**Consultation Response from KC,
Highways Development Management**

2025/90241 14, Firth Street, Huddersfield, HD1 3BA

**Variation of condition 2 (plans) on previous permission 2023/93782 for erection of extensions
and alterations to form 16 student apartments**

Date Responded: 07/07/2025

2 Proposed Ground Floor Plan
1 : 100

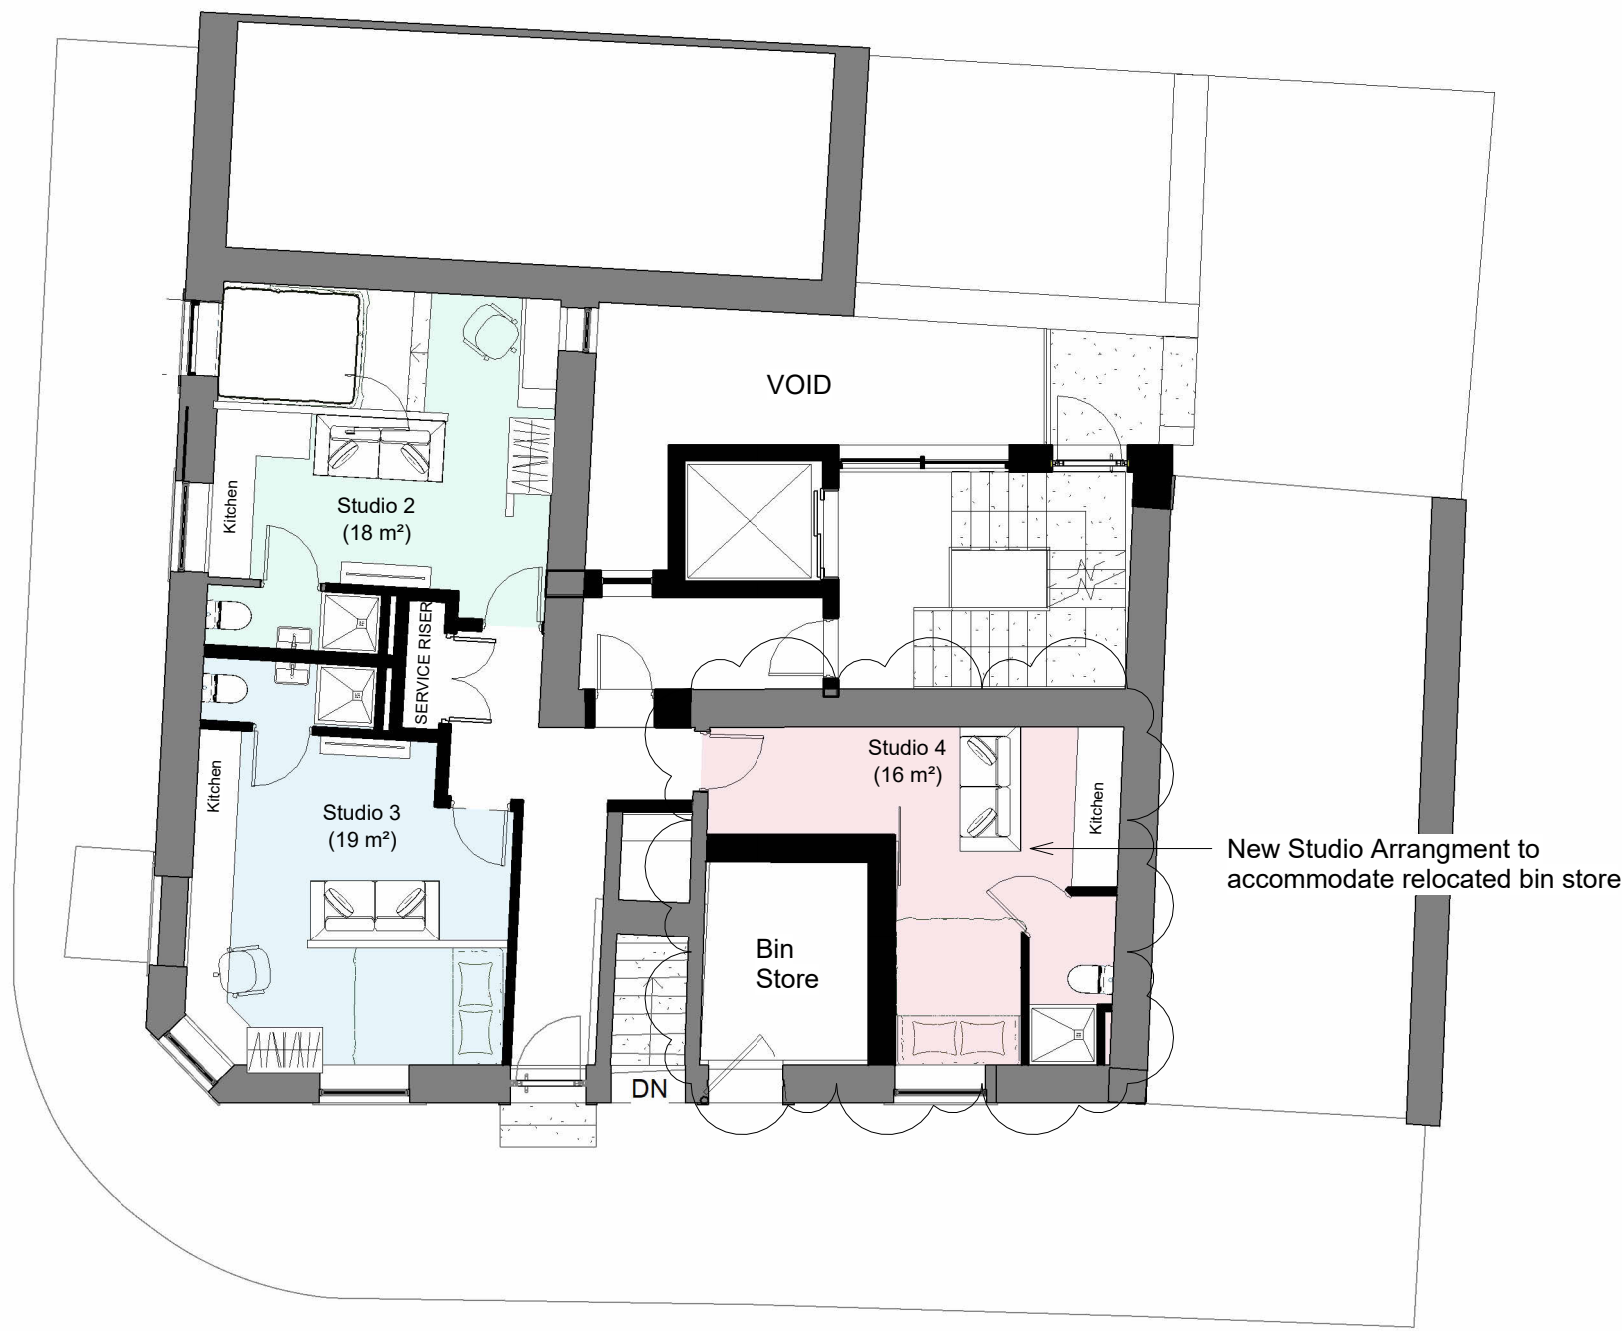
Waste collection is still expected to occur at the kerb side and again a waste management plan (included as condition 6 of permission 23/93782) will need to be suitably amended to include the changes made to the waste storage room access.

The variation is to the layout of the ground floor of the site and is to incorporate a waste storage location within the site due to the originally proposed location not being accessible to the applicant.

The access to the proposed new waste storage location is approximately 6m to the west of the original collection presentation point on Firth Street and this should not have an impact on kerb side collection as previously proposed.

The new location and changes in operation for collection from this point will need to be included within the waste management plan included within condition 6 of previous permission 23/93782. This should include responsibilities for opening the gate and ensuring the bins are not left where they can obstruct the adopted footway for highway safety reasons. This was previously submitted for discharge as 25/90218. We would not be able to support any applications that cause an accumulation of bins obstructing the adopted footway for highway safety reasons and so this should be addressed as a part of 25/90218.
